**Consultation Response from KC,
Trees****2026/90211 West House, Oxford Road, Gomersal, Cleckheaton, BD19 4AU****Erection of residential development for 9 dwellings with associated works****Date Responded: 20/03/2026****Responding Officer: JD****Responding Ref: 06/22**

The proposed development site is complex and in a historically significant location. There is TPO 06/22 which covers almost all the trees within or adjacent the site and this TPO was preceded by TPO SP2/70.

Proposed Site Plan - Overall 1 : 500

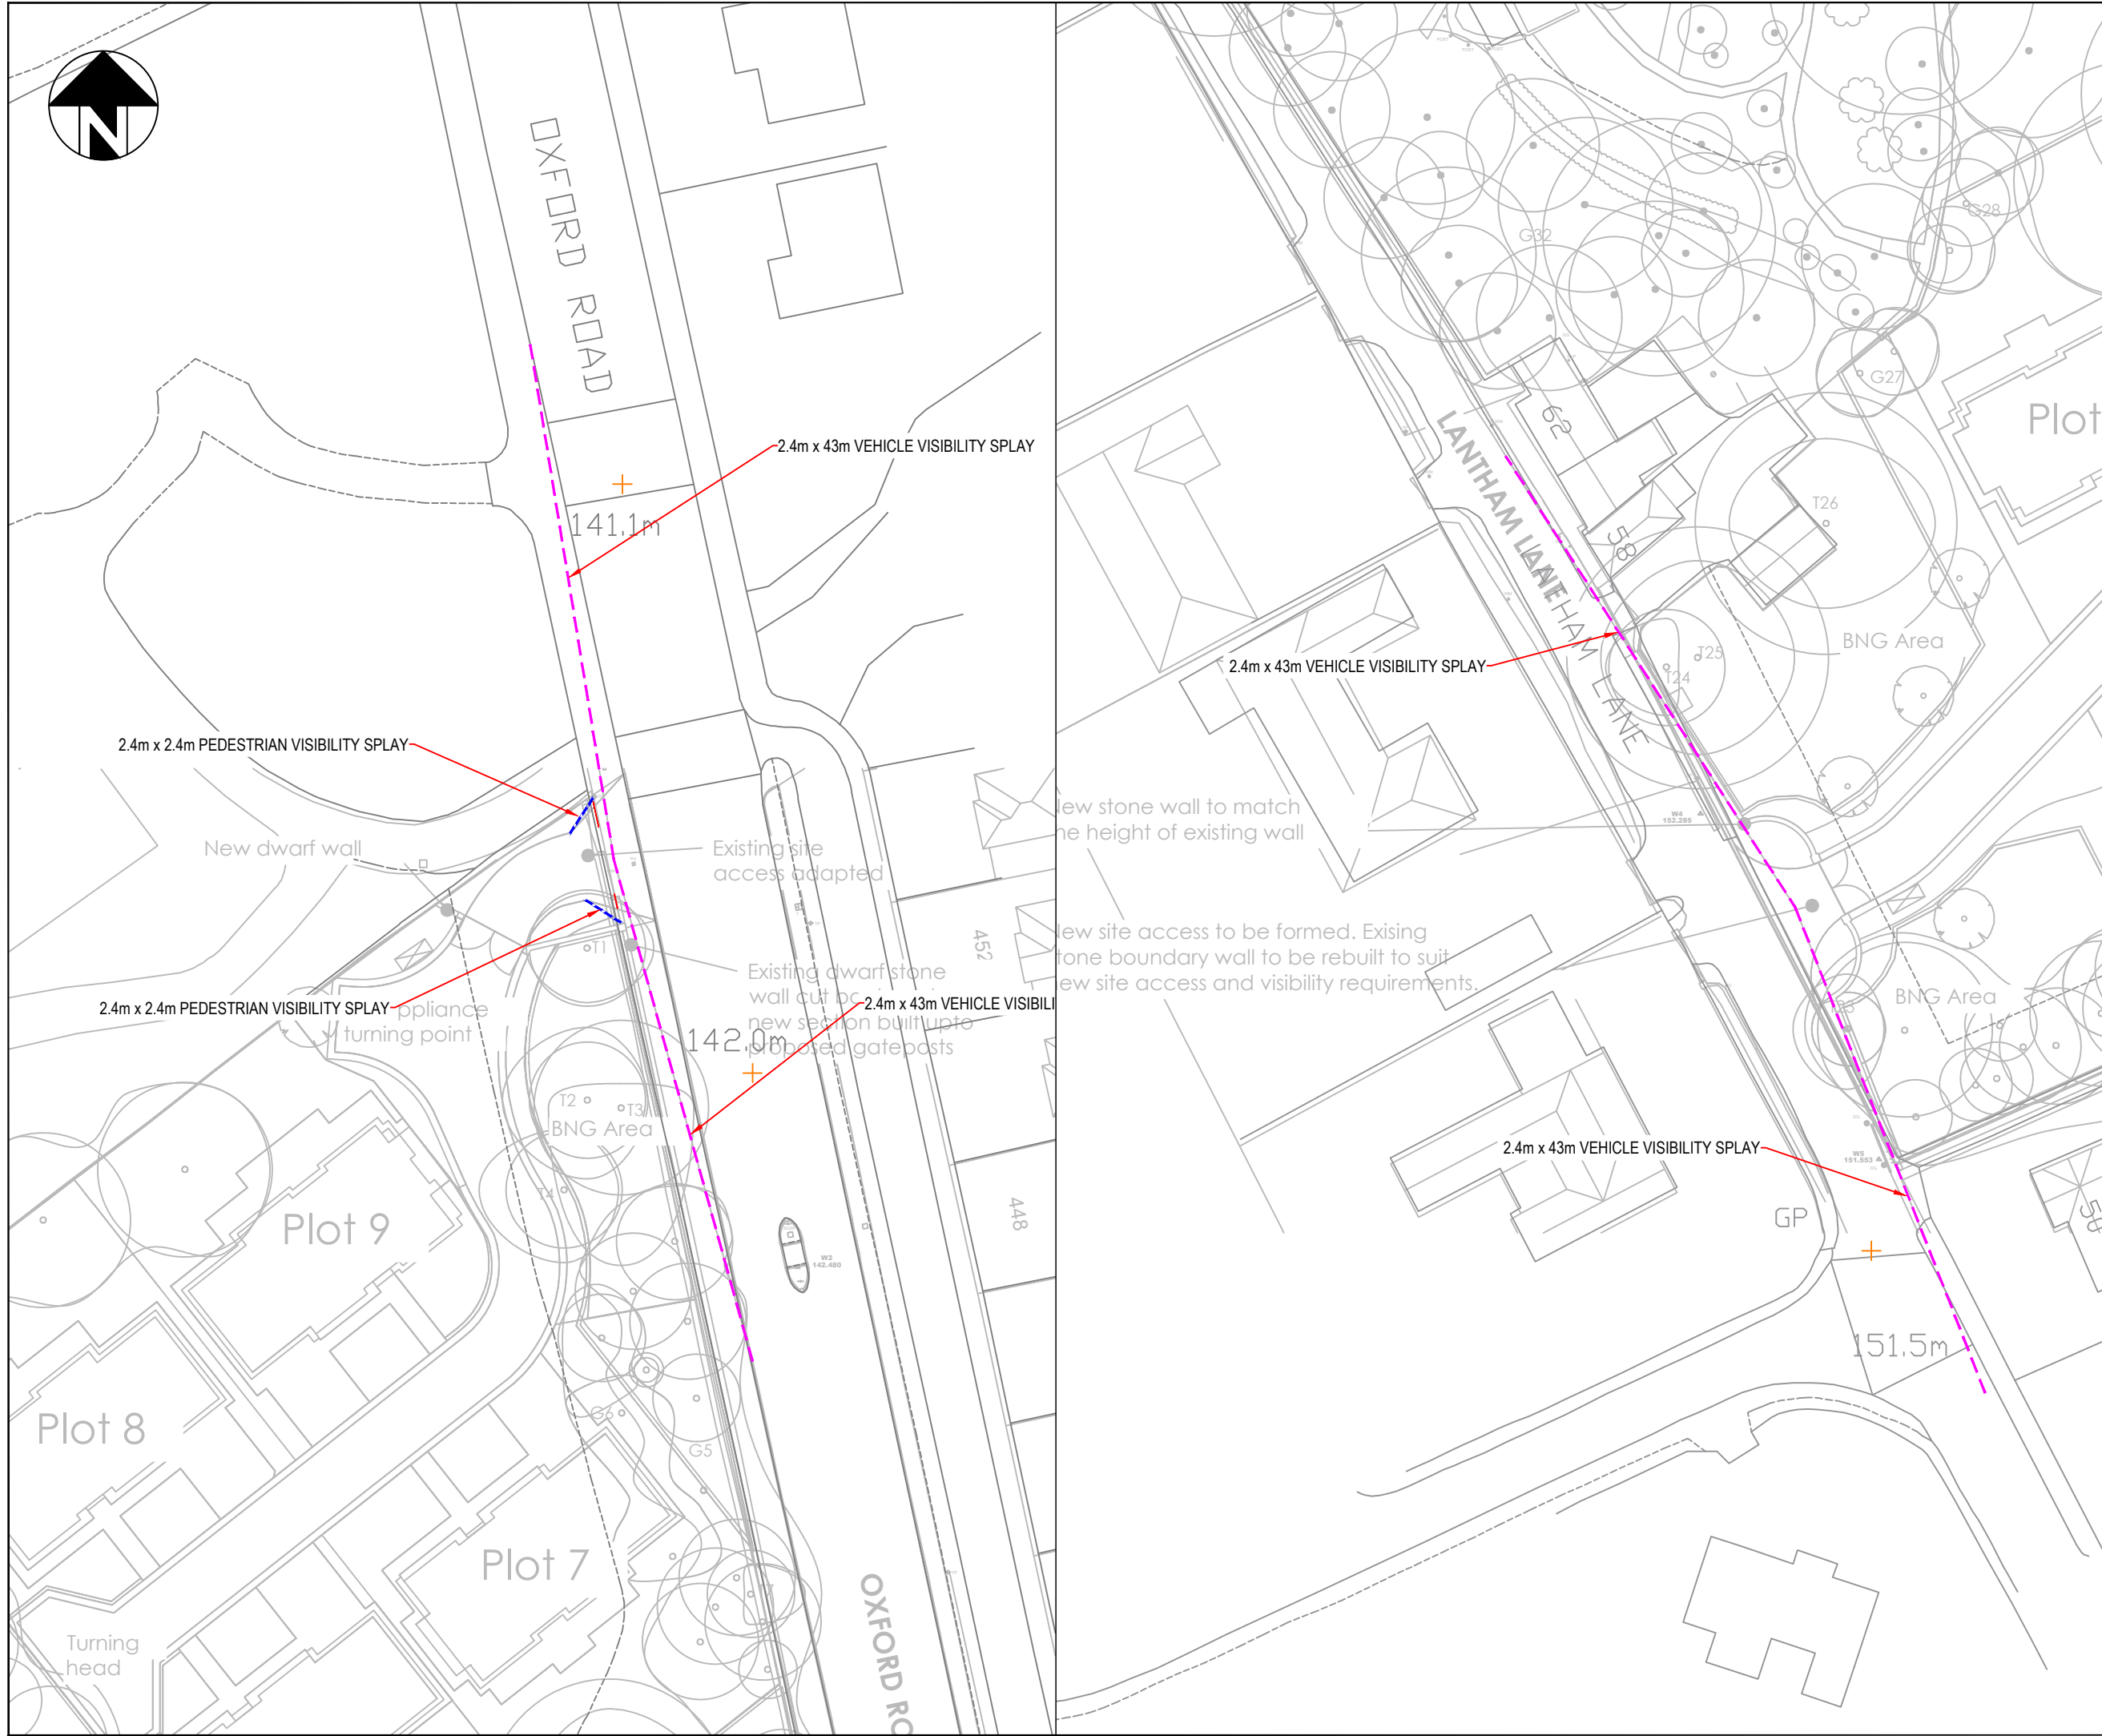
The proposed access point from Oxford Road – There is a live enforcement investigation into the felling of a TPO'd tree without permission in this location. The tree in question was situated directly adjacent to the south post of the existing access gate. When TPO 06/22/w1 was amended by request to not include the access gate so it could be maintained, the tree officer at the time stated that there were currently no trees within the area proposed to not be covered by the TPO, in effect meaning any trees present in this area were included within the amended TPO. This tree has been felled and therefore would require replacement planting in the same location. This effectively means the access point is not viable at this location.

Access road being built over T4's root protection area – Whilst the methods described in the submitted AIA and AMS "New surfaces to be constructed using 'no dig' cellular confinement system" are usually acceptable in instances of more minor incursions into RPA's, this proposal shows the road covering almost 50% of this trees rooting system. KC trees is of the opinion that this would have a detrimental effect on T4 and would also bring vehicles traveling on this road into very close proximity to T4's stem making the likelihood of damage high. There is also no pre-development pruning to be carried out on this tree which means the tree's canopy is likely to be struck by construction machinery due to the canopy hanging over the tree protection fencing.

Removal of 2 trees within G6 – Whilst the trees may be graded as category C trees individually they also are part of the wider woodland TPO and therefore their removal must be weighed against the combined effect on the wider woodland. This woodland has seen systematic felling over the years and is relatively thin and therefore these trees being removed would have a significant impact on the woodlands shape and structure. It is also noted that within the tree survey they are noted as having no defects that require any works on an Arboricultural level, meaning their removal would be purely to facilitate the development. For the reasons mentioned above this is not deemed acceptable justification for the loss of trees, making plot 7 unviable.

Other notes – It is also noted that TPO tree 06/22/t14 (stump can be seen on google maps aerial) was felled with permission, however this tree requires replanting as per conditions set when the tree was approved for removal). This is represented on the submitted tree information as part of the new planting proposed however it is situated immediately adjacent the turning point to the north boundary without sufficient forethought for future growth and the effect that may have on the turning point.

The proposed access point from Latham Lane – From a desk-based assessment it shows that between 2015 to present this used to be a completely tree lined boundary. All of which were protected either by SP2/70 in the past or 06/22 form 2022 onwards. Any trees with or without permission that have been removed from a TPO require replanting in the exact location they were removed from. Therefore, this gap where the access point is proposed should actually be populated with replacement trees. This makes the proposed access road unviable in this location.

G31 – The submitted tree survey has categorised these trees as category U stating “a group of three trees, all with severe lean, significant bark wounds and decay” There is no further evidence to suggest the degree of decay. Leaning trees are not necessarily dangerous and certain levels of decay can still be deemed safe for many years. There would need to be further evidence that these trees are in fact dangerous before the council would consider their removal. Again, these trees are significant and part of TPO 06/22/w4. Their removal must be weighed against the amenity they provide and adequate evidence must be provided before they can be considered category U trees. If further evidence is supplied and the council agree that the trees pose an unacceptable level of risk then replacement trees would be required to be planted in their place along with enough space to mature. This would make plot 1 and 2 questionable in their viability.
